SUBJECT: Engineering Review Comment
Mountain View Electric Association Inc. (MVEA)

Project Name: Waterbury Filing 1 – Final Plat

Project Number: SF237

LEGEND:

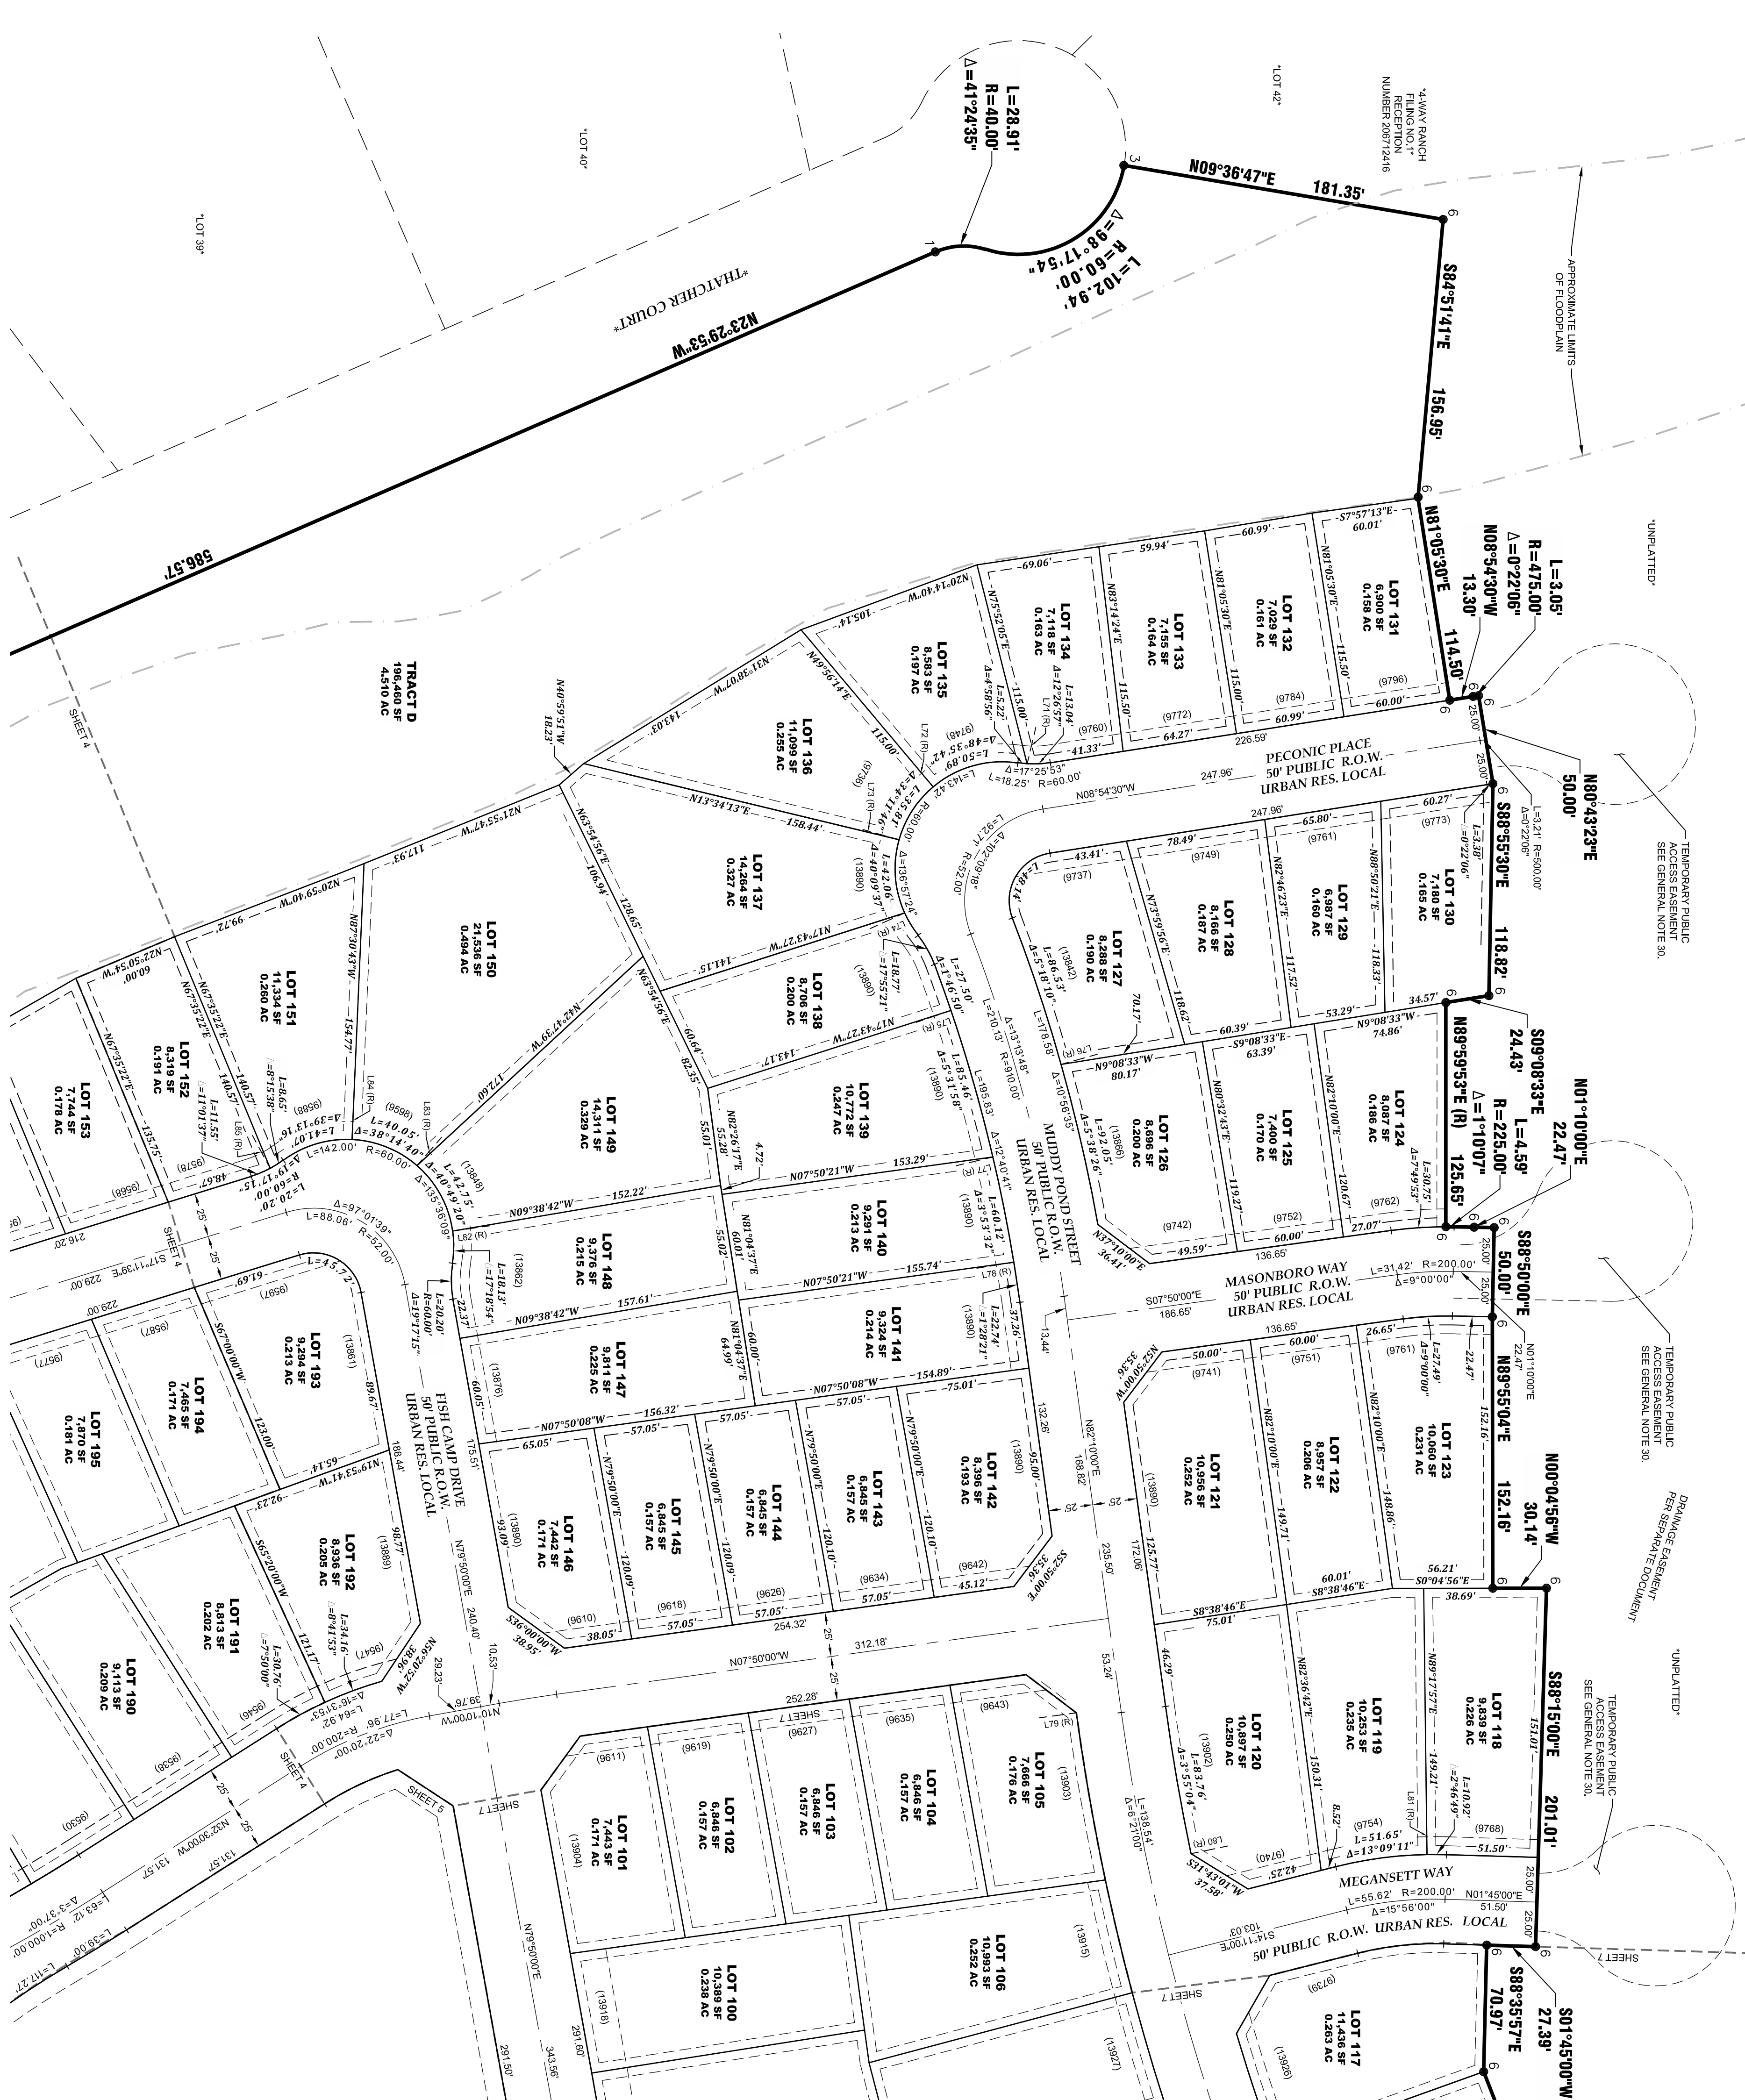
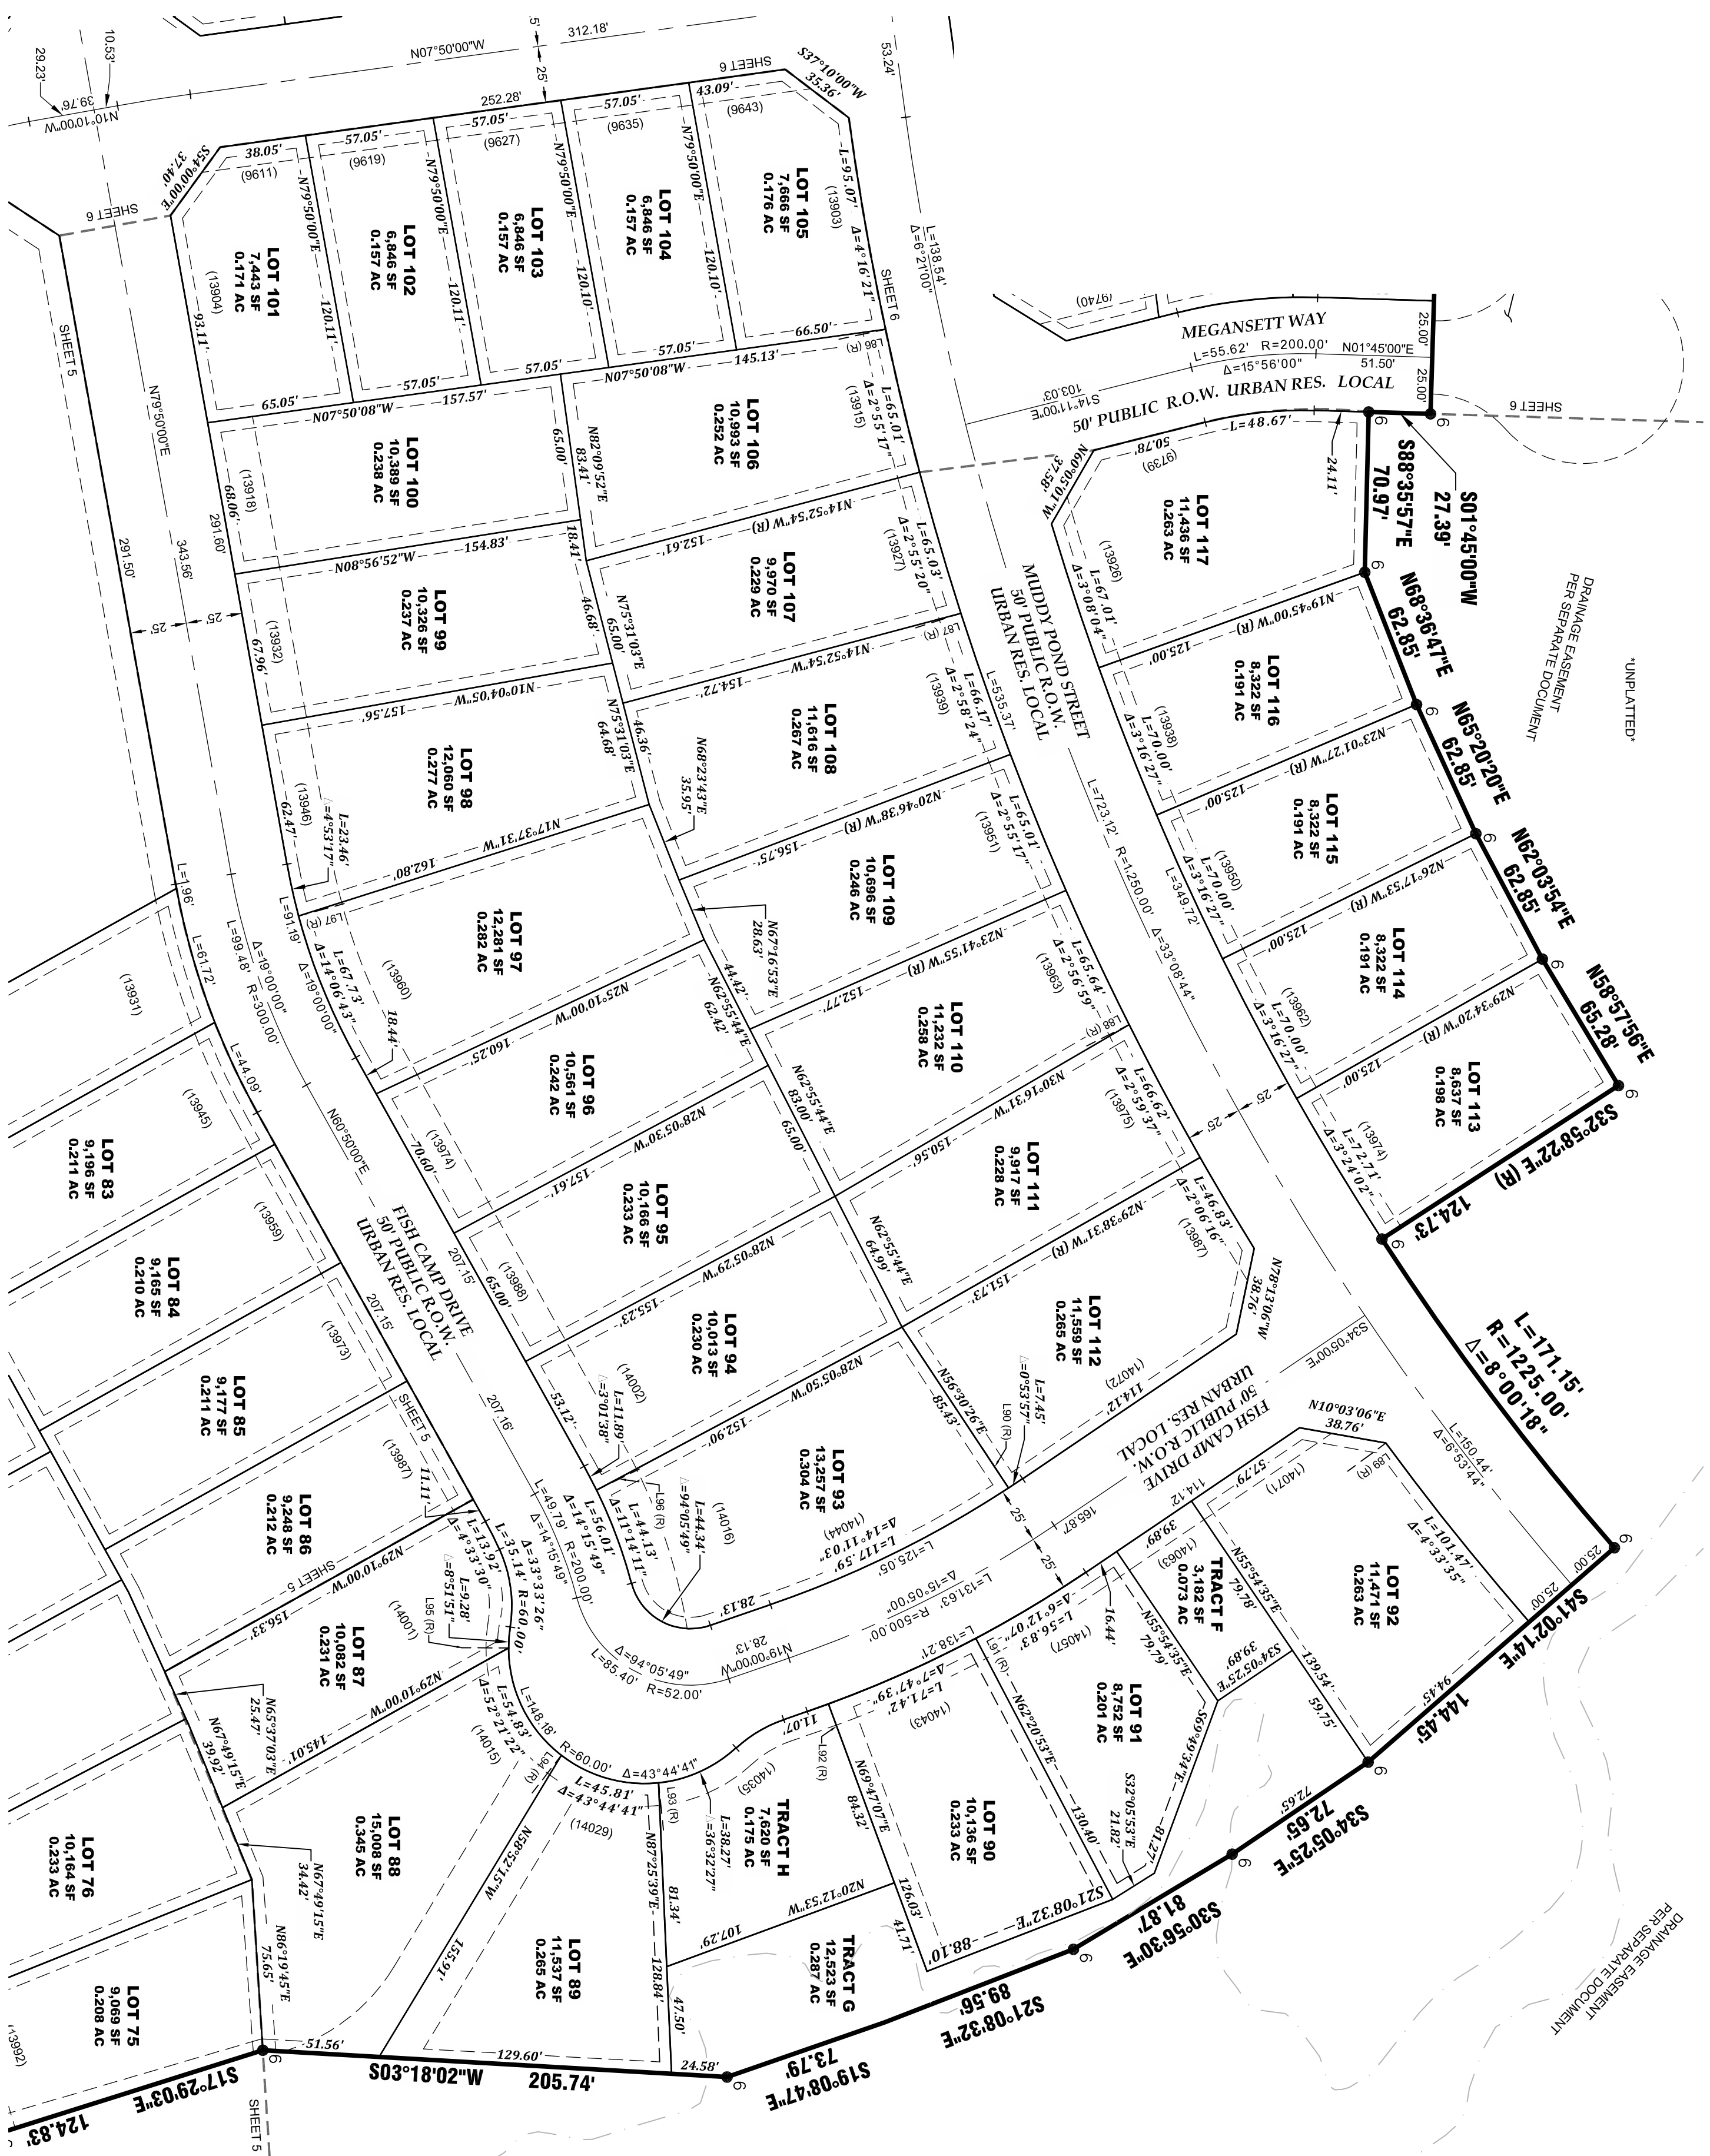
After review of the plat, MVEA is amendable to all the easements **except** MVEA requests a ten (10) foot front lot utility easement in addition to any public improvement easements and **all** tracts include easements. The Tract Table does not align with General Note #7 – Tract Ownership Maintenance. MVEA also requests the platting of MVEA's existing facilities with easements on the plat. Additional easements may be required.
